DECISION DELEGATED TO HEAD OF PLANNING

Application No:	H20-0713-21	Applicant:	Mr & Mrs Githiri
Proposal:	Change of use of barn to residential dwelling using existing access		
Location:	Adj. Chestnut House Broadgate Sutton St James		
Terminal Date:	31st August 2021

SUTTON ST. JAMES TREE PRESERVATION ORDER No.4 1991

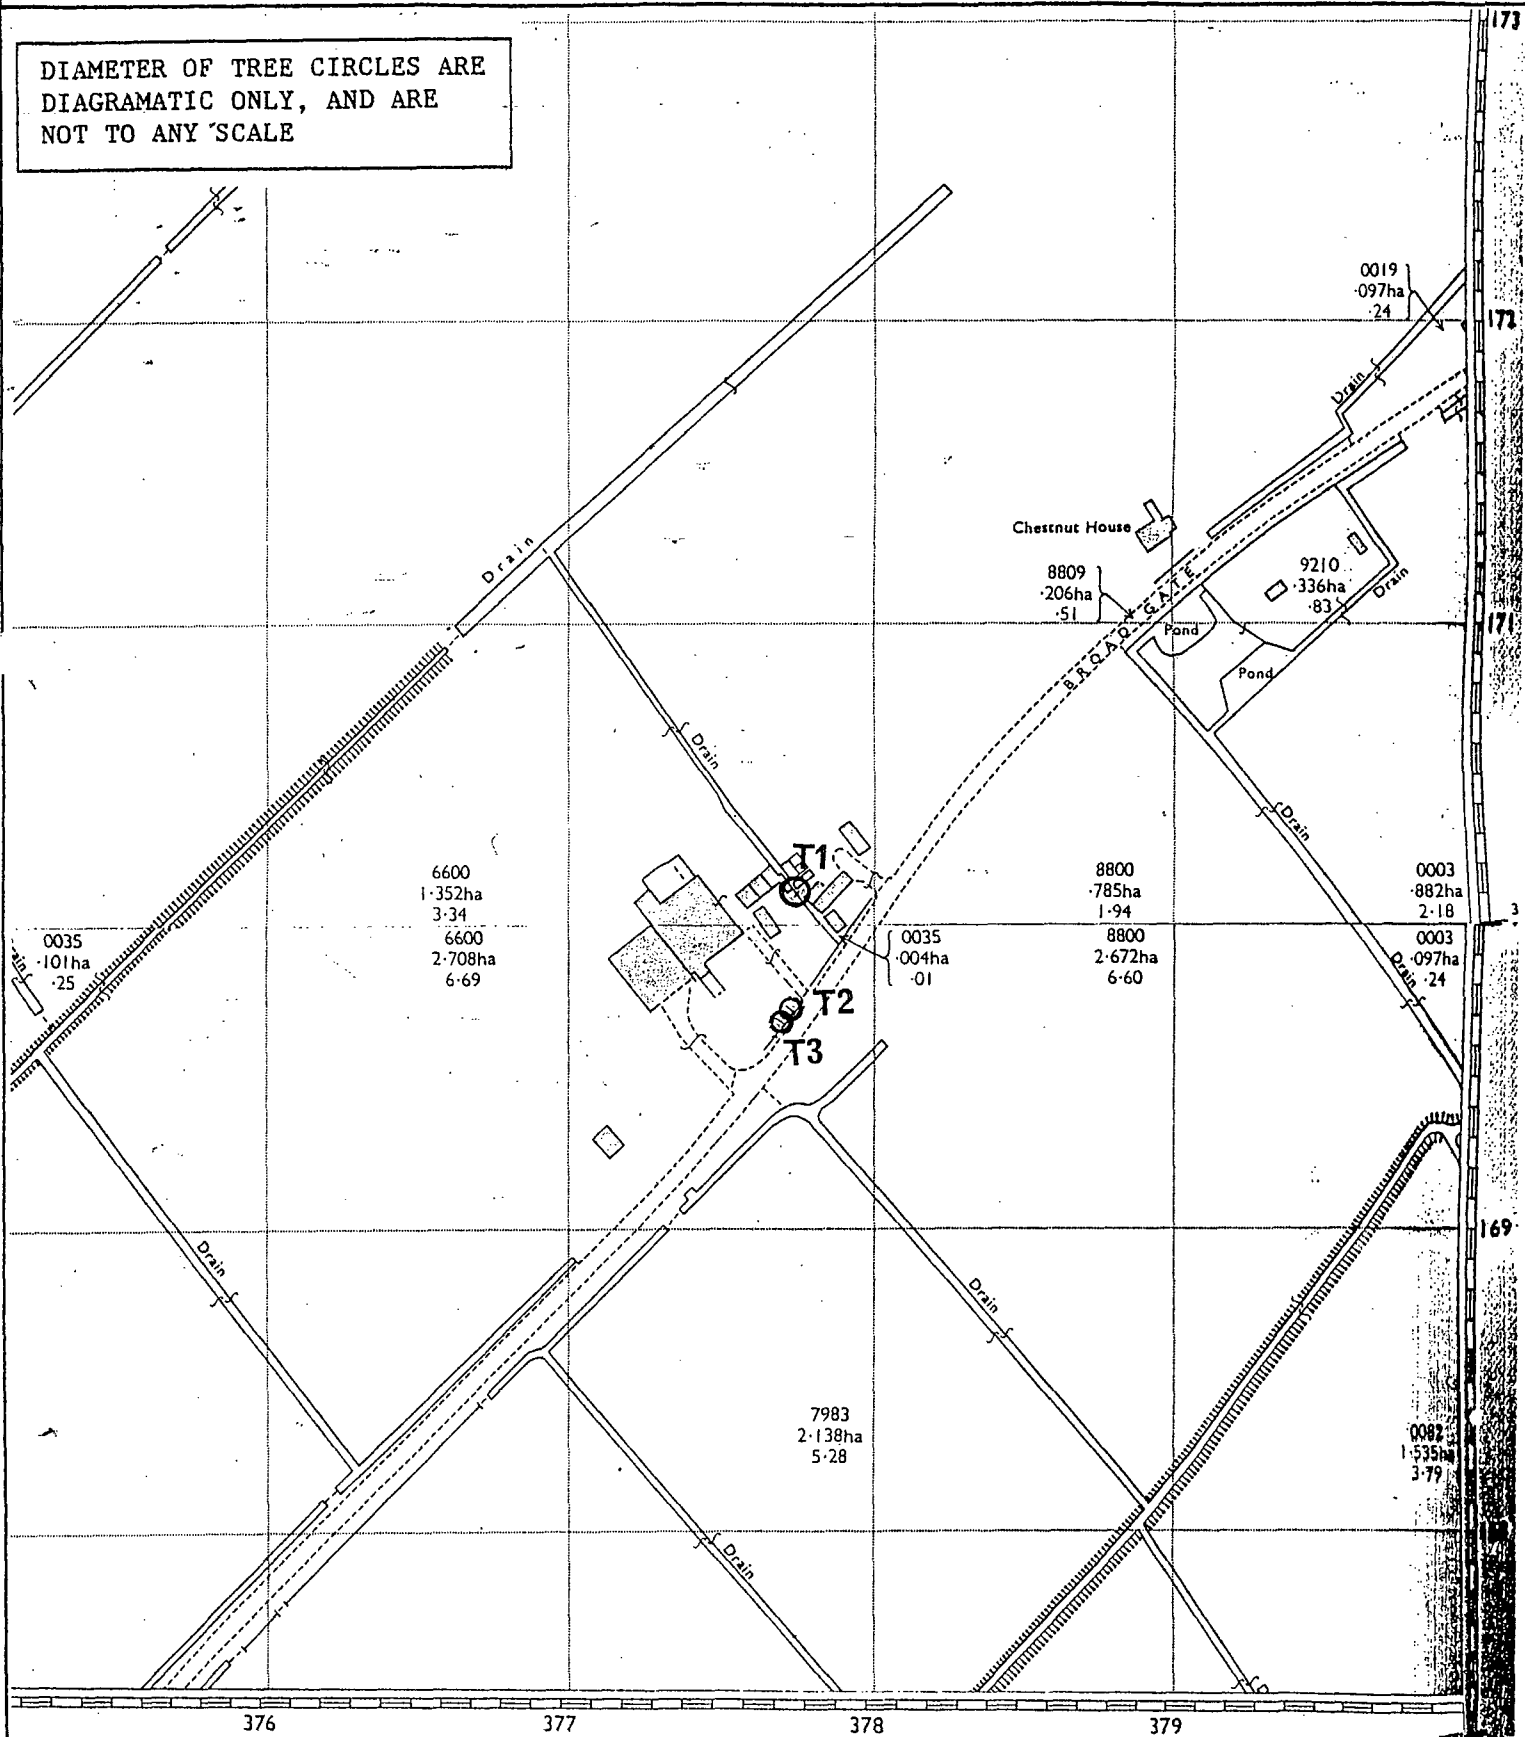
An Ash (*Fraxinus excelsior*) tree, which is the subject of Sutton St James Tree Preservation Order No. 4, 1991, is situated immediately to the south-west of the buildings. Two preserved trees (Giant Sequoia) are situated further to the south-west along the frontage of the industrial premises.

In terms of siting, the buildings are in very close proximity to a preserved Ash tree. It is considered that their conversion to residential would lead to future requests to fell the tree and therefore prejudice its continued existence.

Moreover, an Ash (*Fraxinus excelsior*) tree, which is the subject of Sutton St James Tree Preservation Order No. 4, 1991, is situated immediately to the south-west of the buildings. The development would, if permitted, compromise the tree and result in pressure to remove it, thereby prejudicing its continued existence, to the detriment of the visual amenities of the rural locality.
